Subject: Lake Macquarie Yacht Club Expansion 9 Ada Street, Belmont MP08_0045

**Subject: Submission regarding expansion of Lake Macquarie Yacht Club
at 9 Ada Street, Belmont – MP08_0045**

**Re: Lake Macquarie Yacht Club Expansion, 9 Ada Street, Belmont –
MP08_0045**

CLIENT: **LAKE MACQUARIE YACHT CLUB** DRAWING: **CAR PARK ALTERATIONS PLAN**

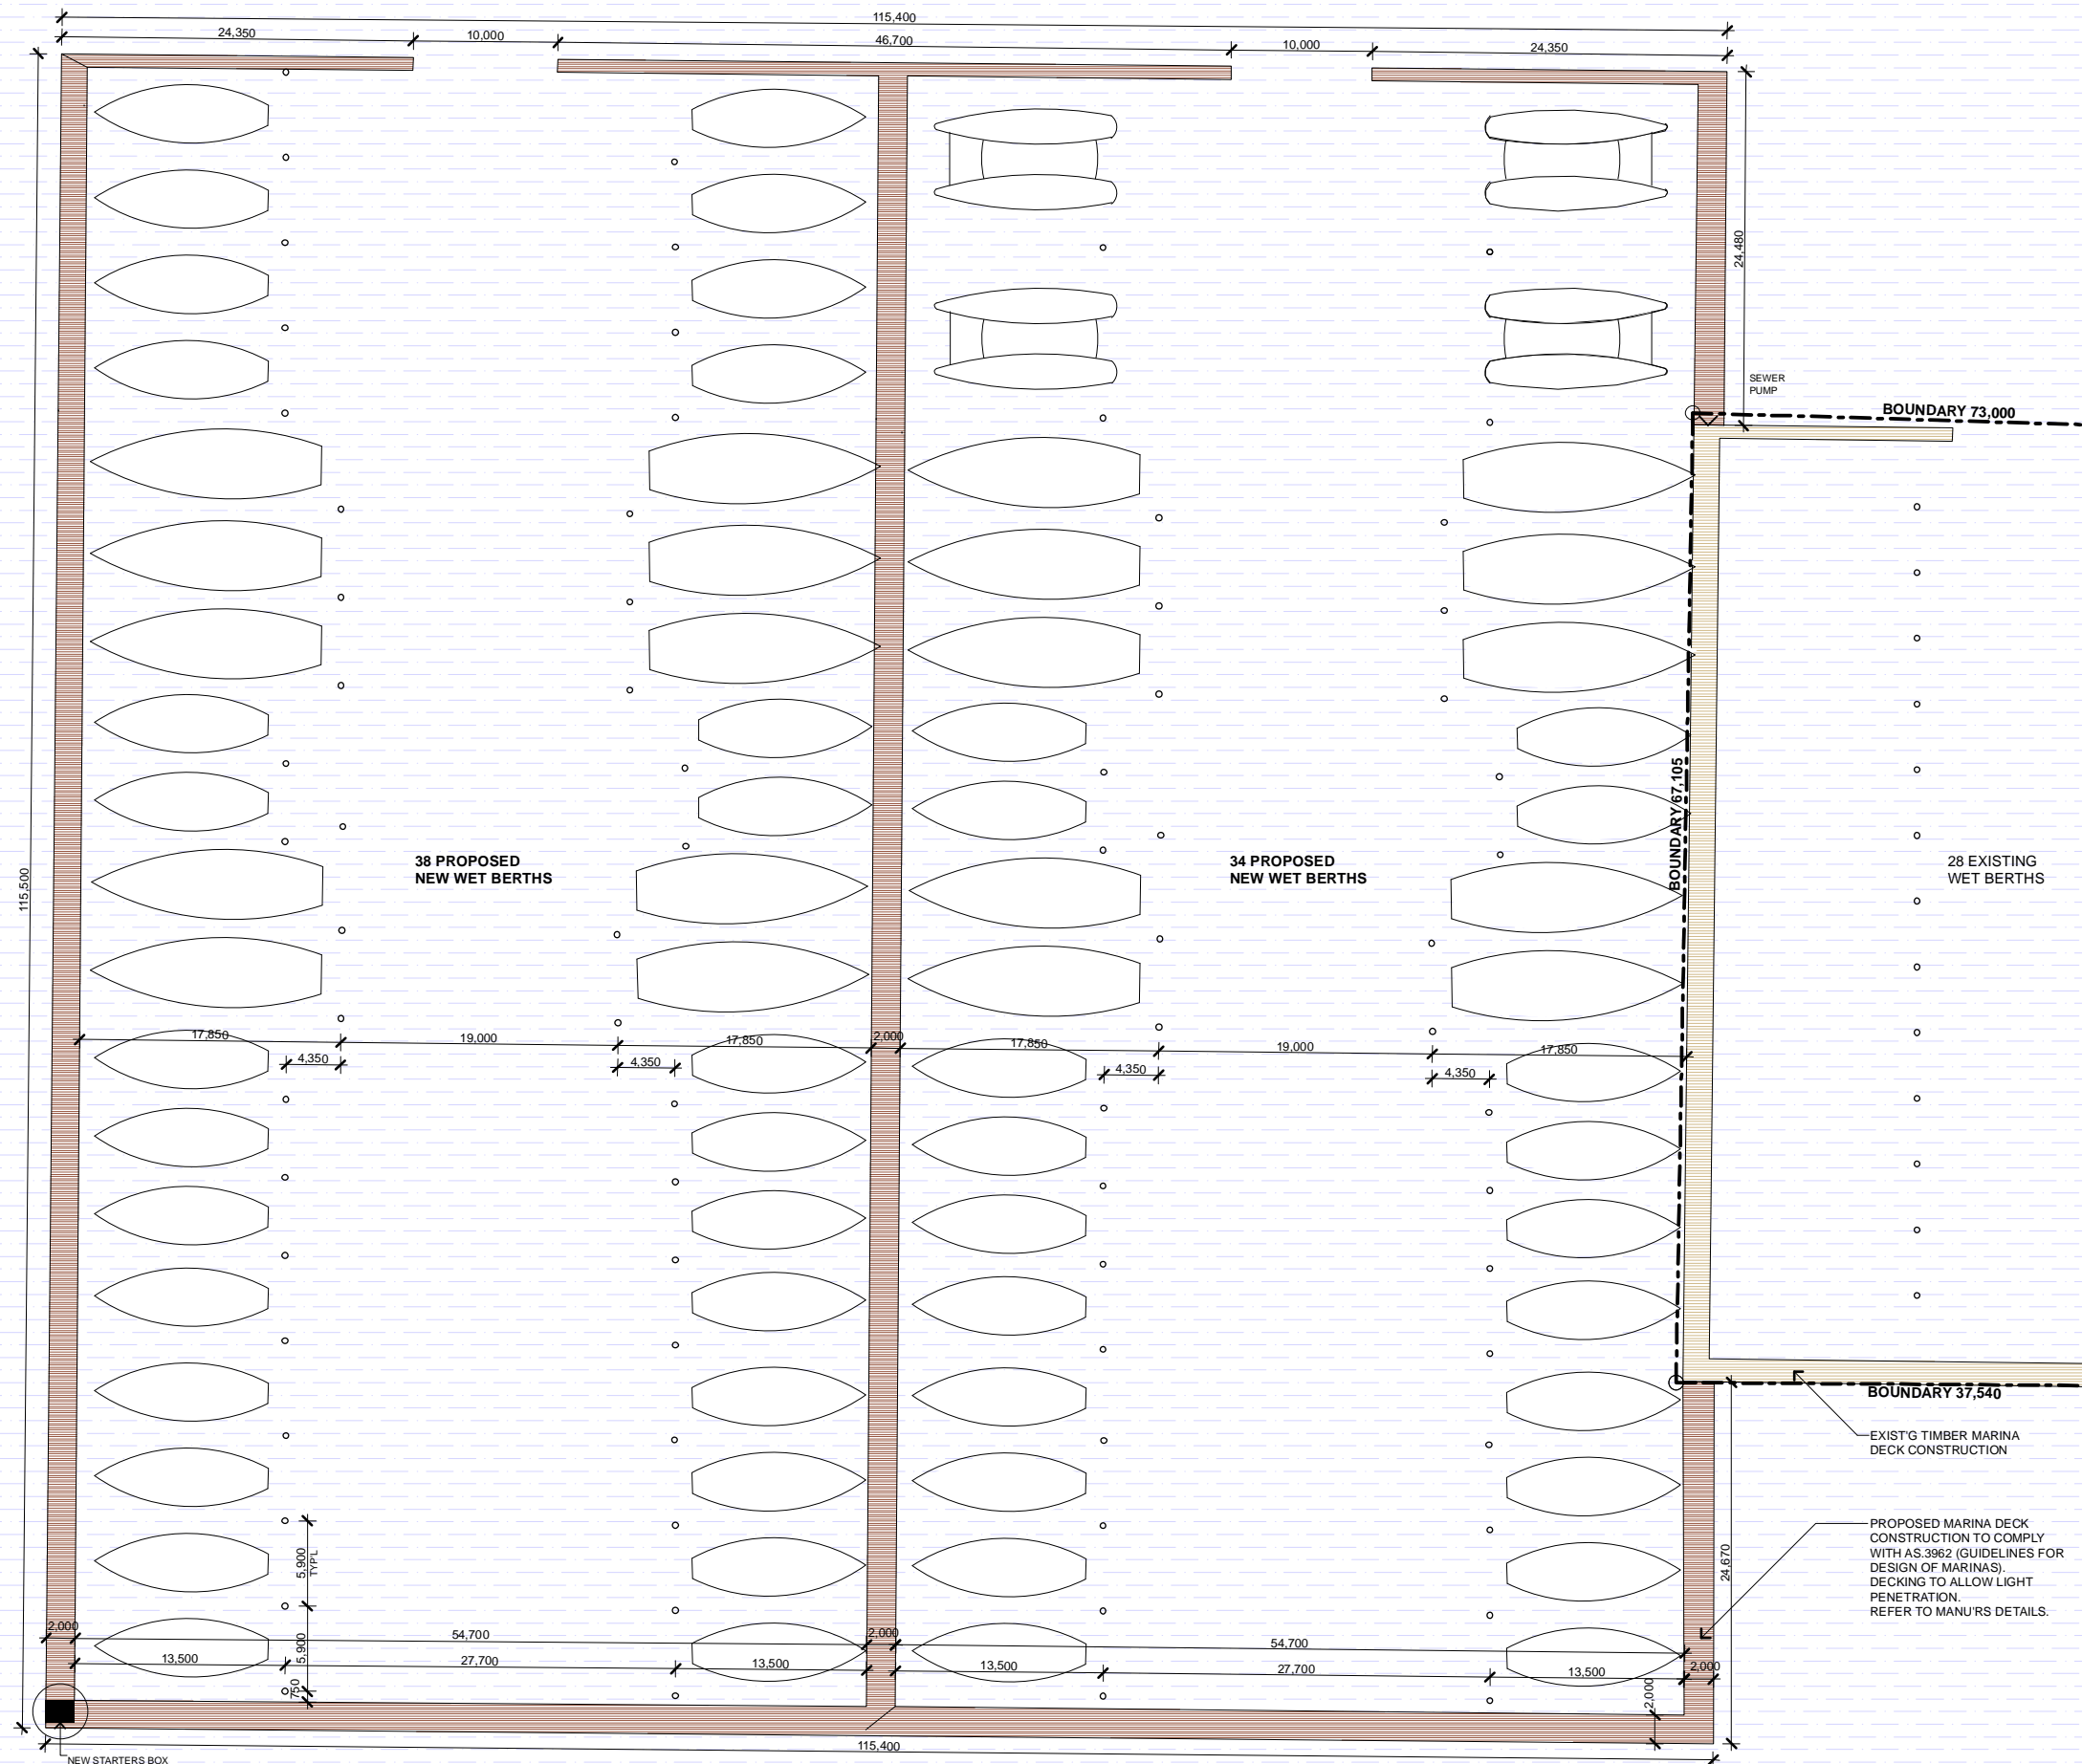
(e) **Car Parking Areas and Structures:** In regards to Section 2.6.7 (Car Parking Areas and Structures) of DCP No.1, the proposed disabled parking spaces do not conform with AS2890.6:2009. The spaces are to be 2.4 metres wide, with a 2.4 metre shared area adjacent.

(f) **Servicing Areas:** Having regard to Section 2.6.10 (Servicing) of DCP No.1, turning movements into and out of the loading area should be provided, as the dry berth spaces and adjacent disabled zone appear to make manoeuvring difficult.

CLIENT: **LAKE MACQUARIE YACHT CLUB** DRAWING: **CLUBHOUSE SOUTH & WEST ELEVATIONS**

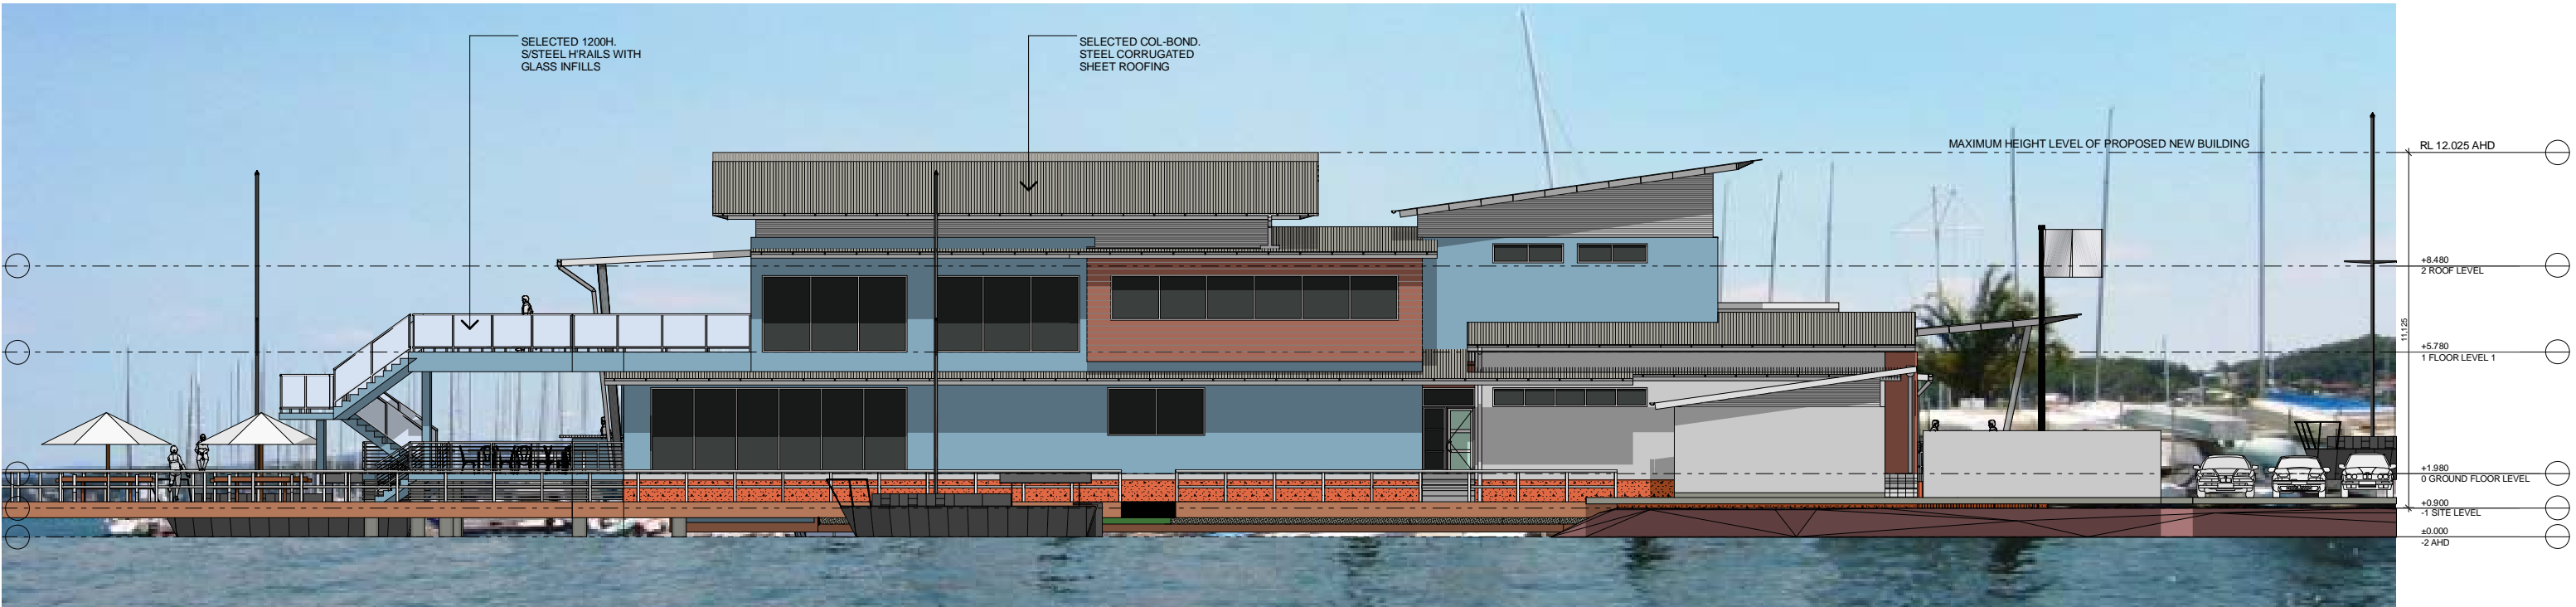
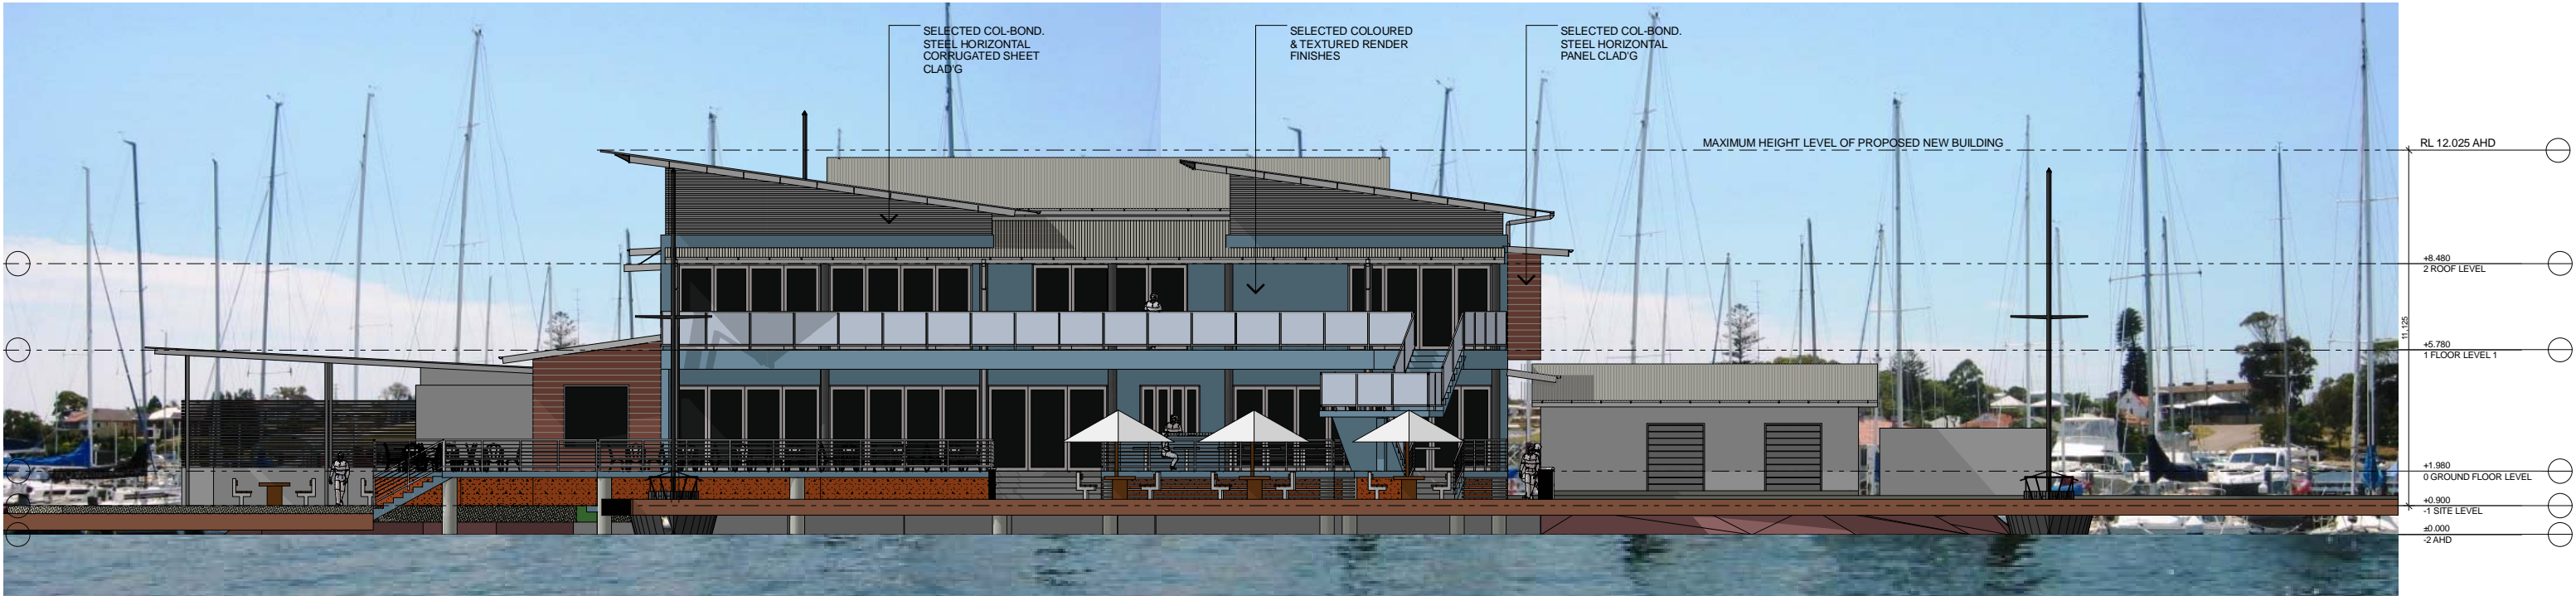
- (a) The applicant should consider minor amendments to the southern elevation of the clubhouse to improve the visual presentation of the development and break up the bulk of the building. It is recommended that this be achieved through a variety of building materials, colours and finishes.
- (b) Feature canopy trees or palms should be planted in the existing lawn / paved area to the north of the clubhouse to break up the bulk of the building as well as provide shade and landscape amenity to the recreational area.
- (c) All the existing trees within Cullen Park with good health conditions should be retained and protected during the construction stage. The landscape features in Cullen Park should be maintained and enhanced by tree surgery maintenance works and suitable shrub and groundcover planting at the feature areas including the entrance and perimeter of the proposed car park.
